Outline application with some matters reserved for 36 no. houses. (This application is a departure from the development plan)

The Lillies Holiday Park Yapton Road Barnham Bogner Regis West Sussex PO22

BN/6/10/

PROJECT	The Lillies		DATE	15/02/10
TITLE	Illustrative Site Layout		DRG NO	IBA/315/03
SCALE	1 : 500		REVISIONS	-
		Orchard House Studio 41 West Drive Aldwick Bay West Sussex PO21 4LZ Tel 01243 263241		
		www.ivonblumerarchitects.com

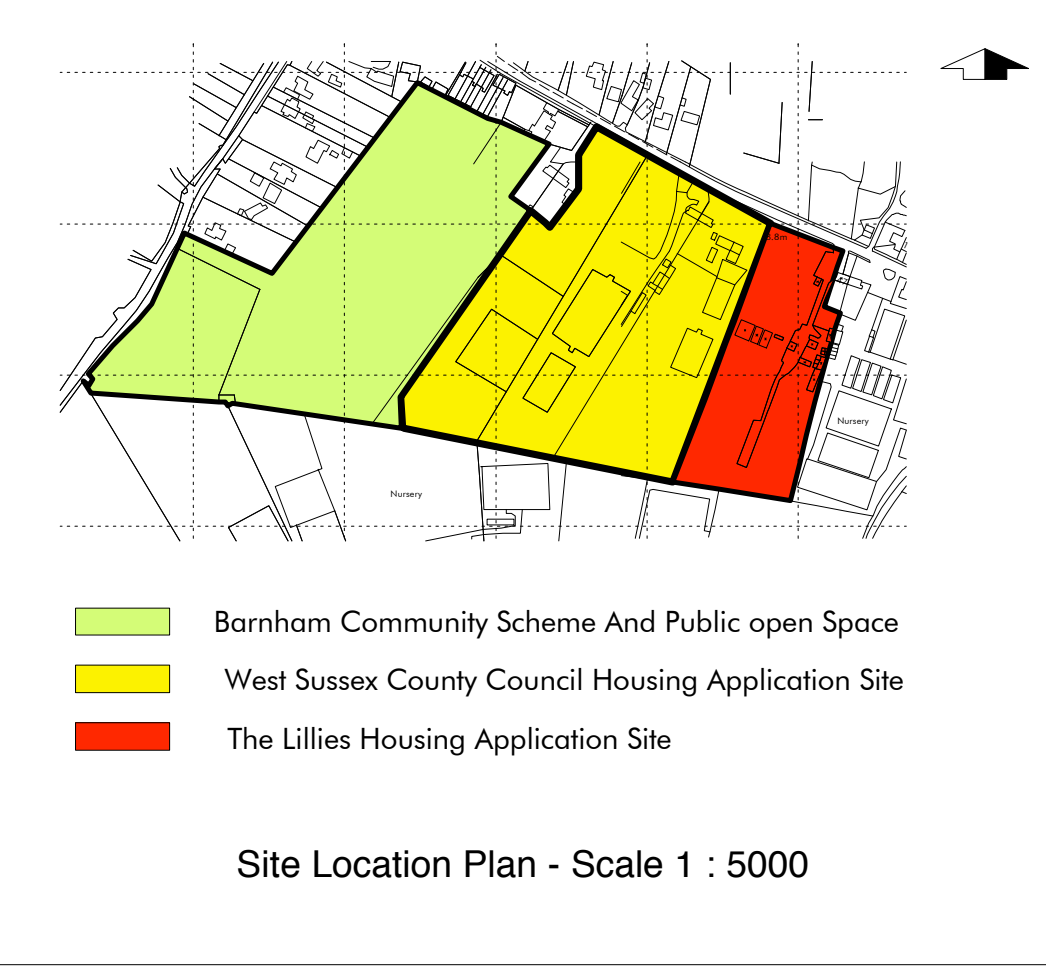
Please find attached a plan of the sewer records showing the approximate position of a 225mm foul sewer and a critical 300mm foul water rising main that cross the proposed site. The exact position of the public sewers must be determined on site by the applicant before the layout of the proposed development is finalised. Please note:

No development or new tree planting should be located within 3 metres either side of the centreline of the public sewers and all existing infrastructure should be protected during the course of construction works.

SUDS systems usually have a significant land take and it is not clear how the SUDS facilities can be accommodated within the proposed layout. Before the proposed layout is approved, we advise that the applicant/developer give consideration to ensure that the proposed means of surface water disposal can be accommodated within the proposed layout.
